SSDA 9403 – 1-2 MURRAY ROSE AVENUE

The Government Architect NSW has been asked to provide independent design review commentary on State Significant Development application SSDA 9403. Please find our response below.

1 ELEVATION_S1_NORTH
1:400 @ A3

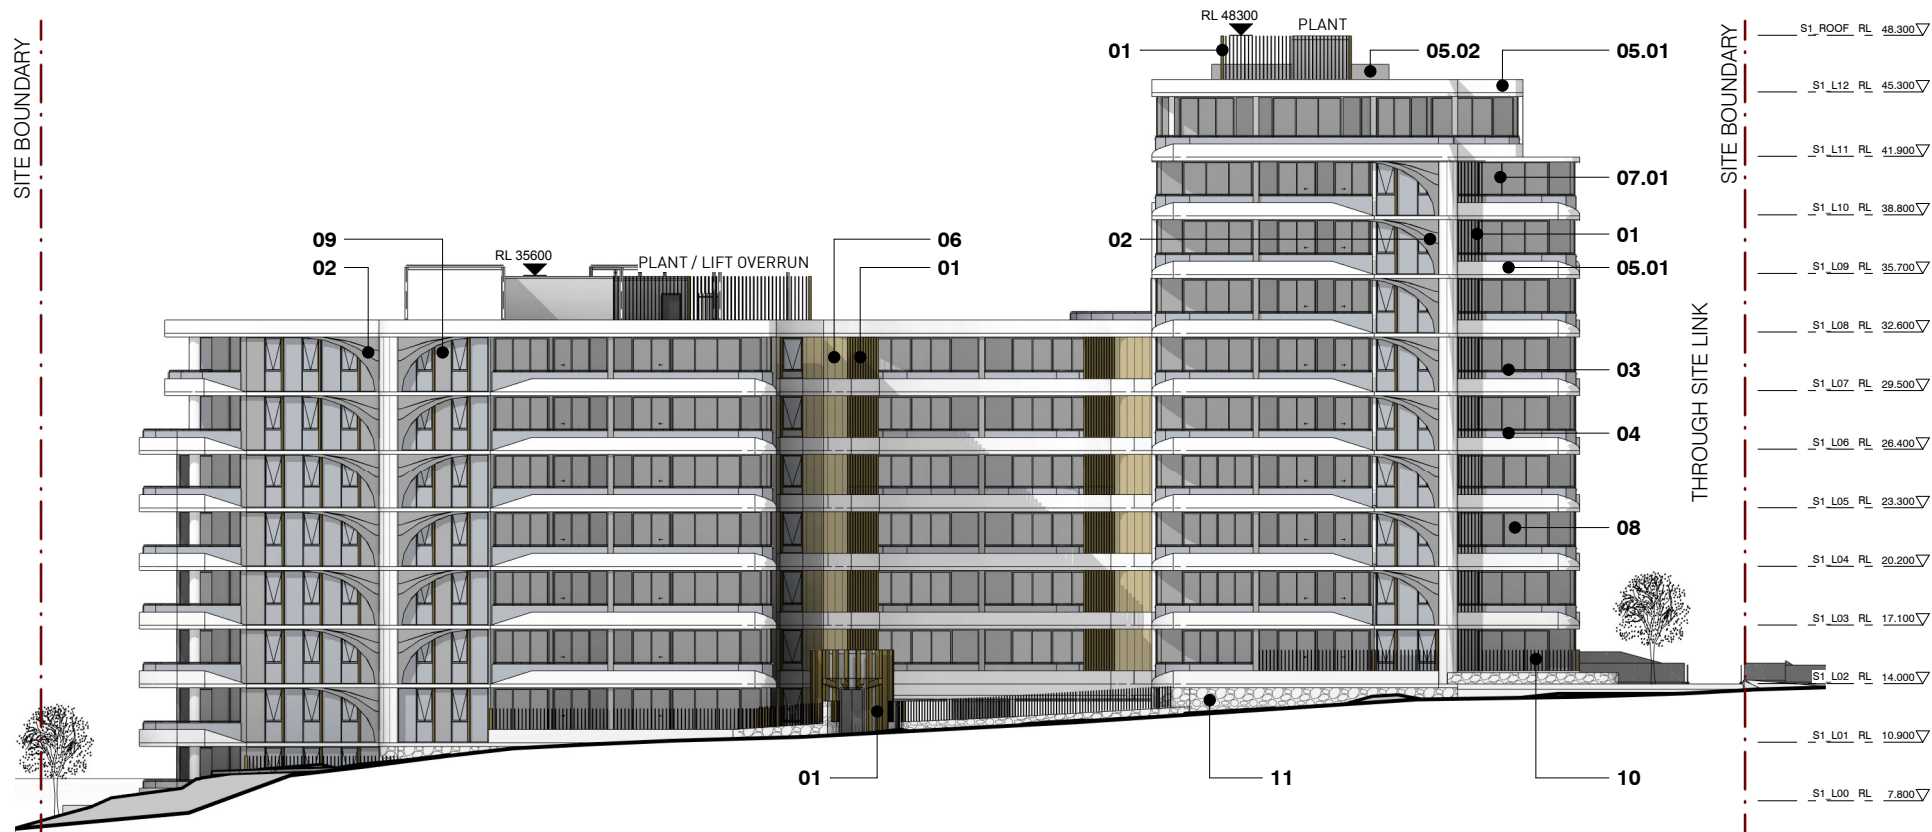
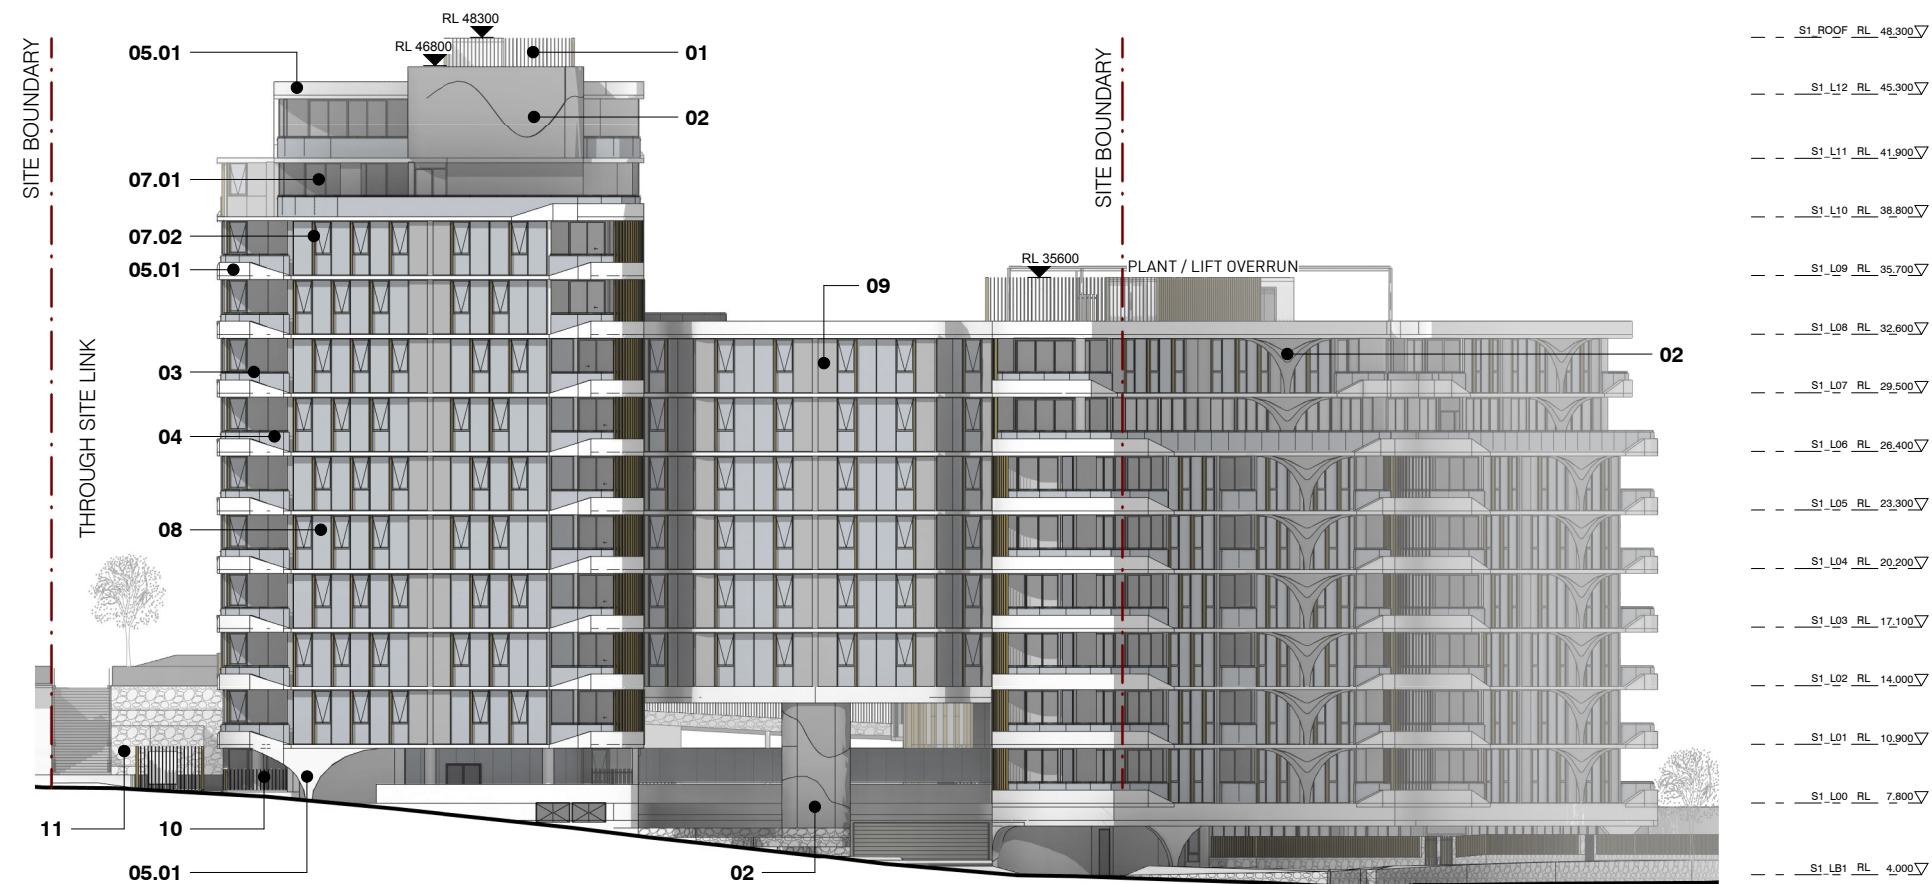
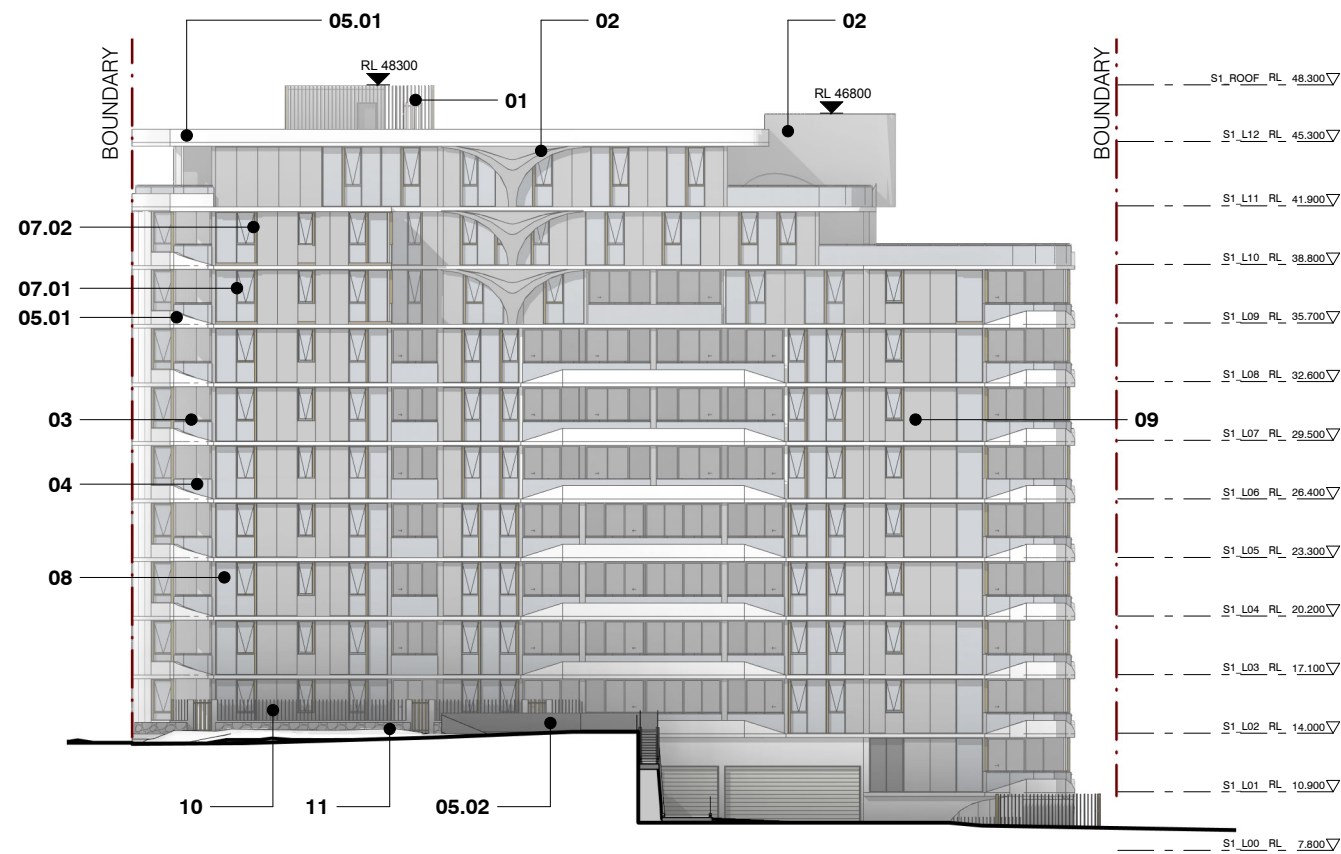
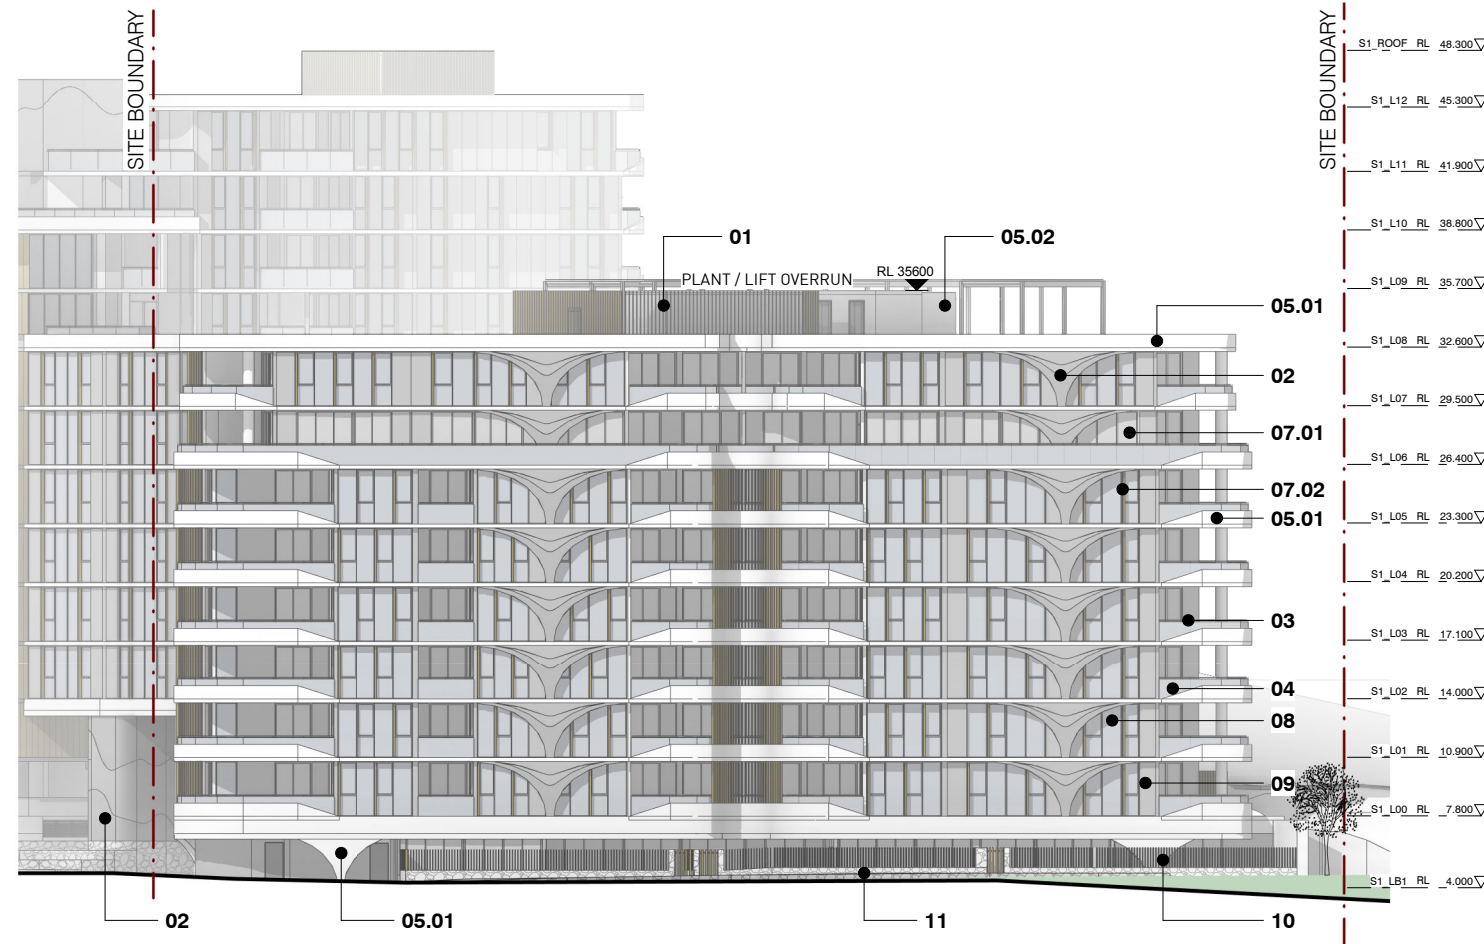
The proponent has generally responded to the comments made through the Competition process. The proposal as developed has generally maintained key architectural and urban design principles established as part of the Design Excellence Competition winning scheme. On the basis of the material submitted the proposal has not yet addressed concerns around achievement of a 6-star Green Star rating and heat loadings to the northern and western facades. We recommend these issues be addressed through the following:

1. Provide modelling to demonstrate the effectiveness of the proposed façade sunshading system, in particular to the northern and western facades.
2. Provide technical details and performance specification of the glazing units proposed for all facades.
3. Provide Green Star scorecard and details of how the 6-star rating will be achieved.
